Re: SSD-13895306 for alterations and additions to Newcastle Grammar School – Park Campus

I submit details of my numerous concerns about the proposed development below.

**Rooftop Play**

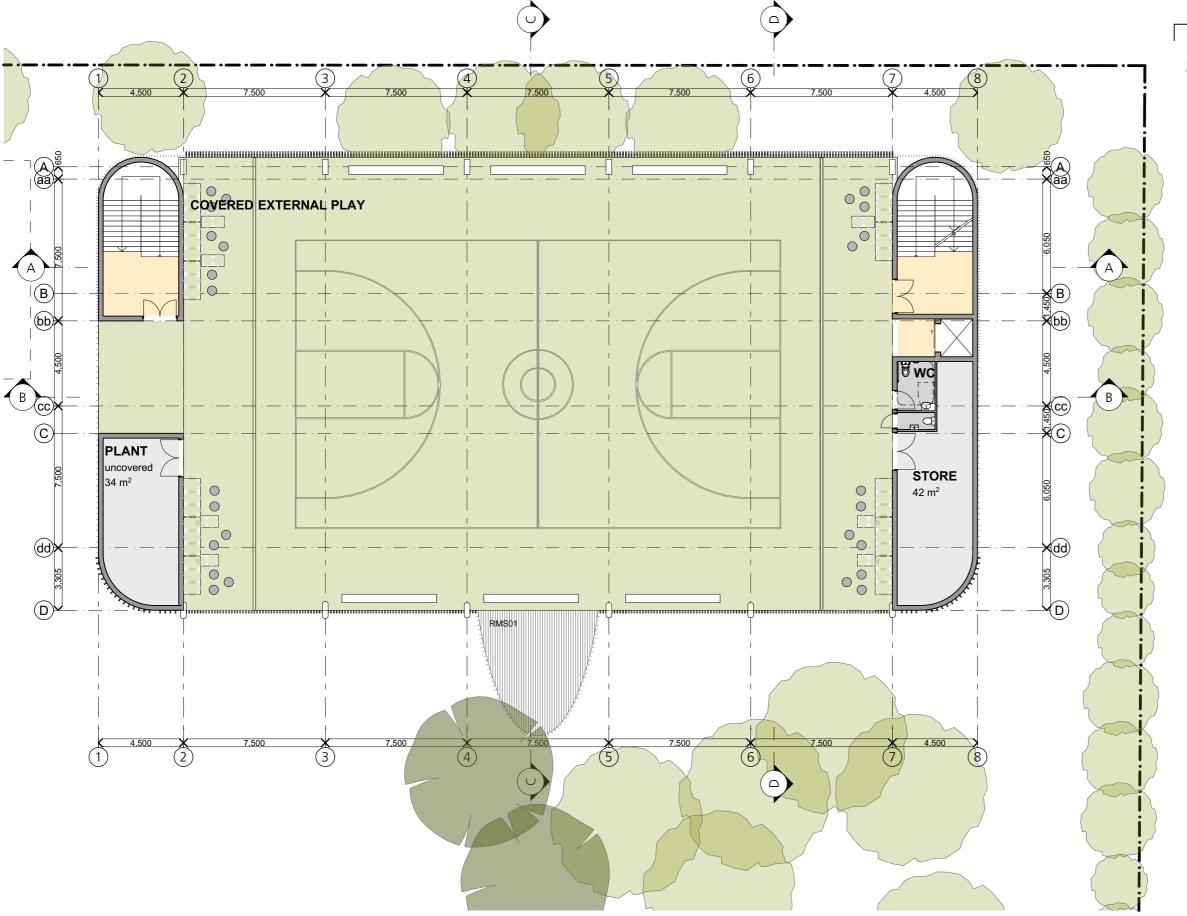
- a) Losing their onsite green space and having it replaced with a west-facing (i.e., facing Union St) rooftop play area, no doubt to be covered in heat retaining materials such concrete, soft-fall "rubber", and Astroturf. It's unclear whether shade provisions would reduce such effects sufficiently for student comfort and they would be likely to reduce airflow. In warmer months, the sea breeze generally arrives after lunchtime, meaning that morning recess and possibly lunch recess could be extremely uncomfortable for students.

- b) There is also no mention in the document I received about how students with mobility issues would access the upper floors and rooftop playground.
- c) The obvious additional time for students waiting for extended periods in cars for drop off and so on caused by the proposed 60% increase in student numbers adds more emotional and physical burden to both students and parents/carers.
